CONSTRUCTION DOCUMENTS  
 FALCON MEADOWS AT BENT GRASS FILING NO. 4  
 FOR  
 CHALLENGER COMMUNITIES, LLC

BENT GRASS MEADOWS DRIVE & MERIDIAN ROAD  
 FALCON, CO 80831 - EL PASO COUNTY

GRADING & EROSION CONTROL INITIAL PLAN

**GRADING & EROSION
CONTROL INTERIM PLAN**

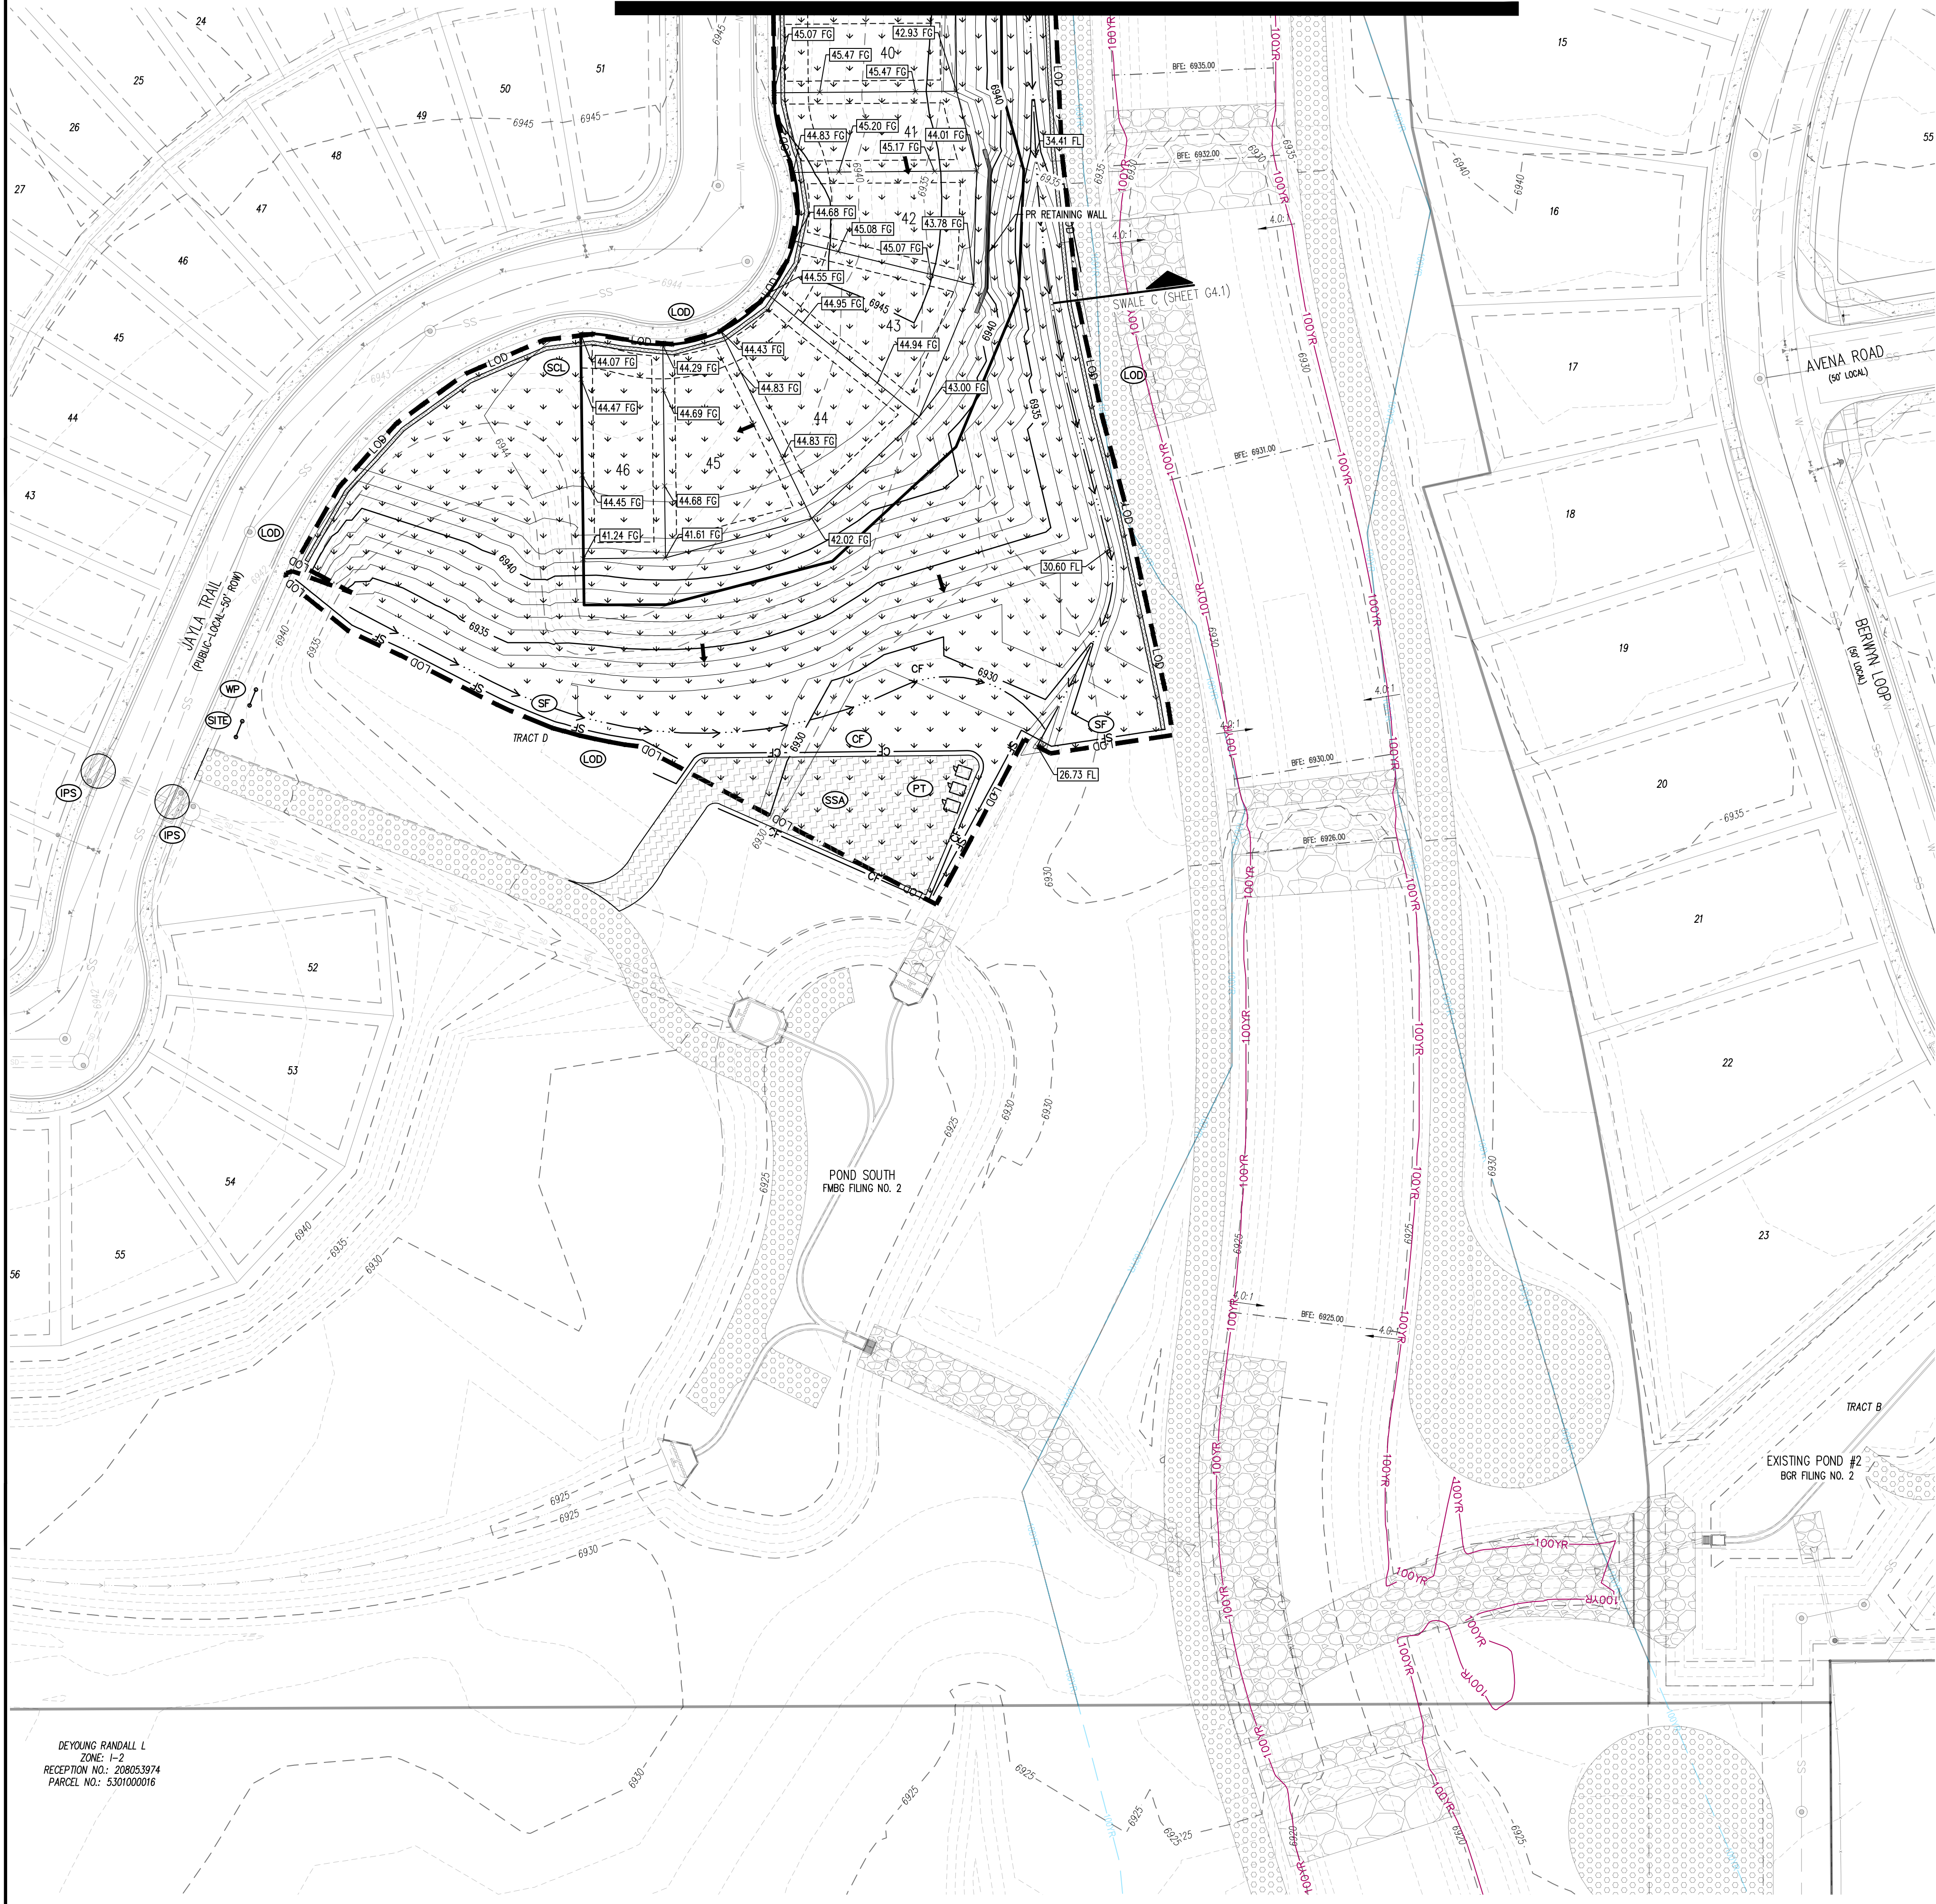
what happens to all of the runoff that is conveyed to this point by the swale? Is this an existing temporary slope drain? If so, would be good to show some form of IP here. Otherwise, add some form of protected temp conveyance from the swale to the forebay.

Label Pond name/number (Existing Pond 1)  
**LABEL IS PLACED**

**PROPOSED STORM INLET IS PRESENT WITH INLET PROTECTION**
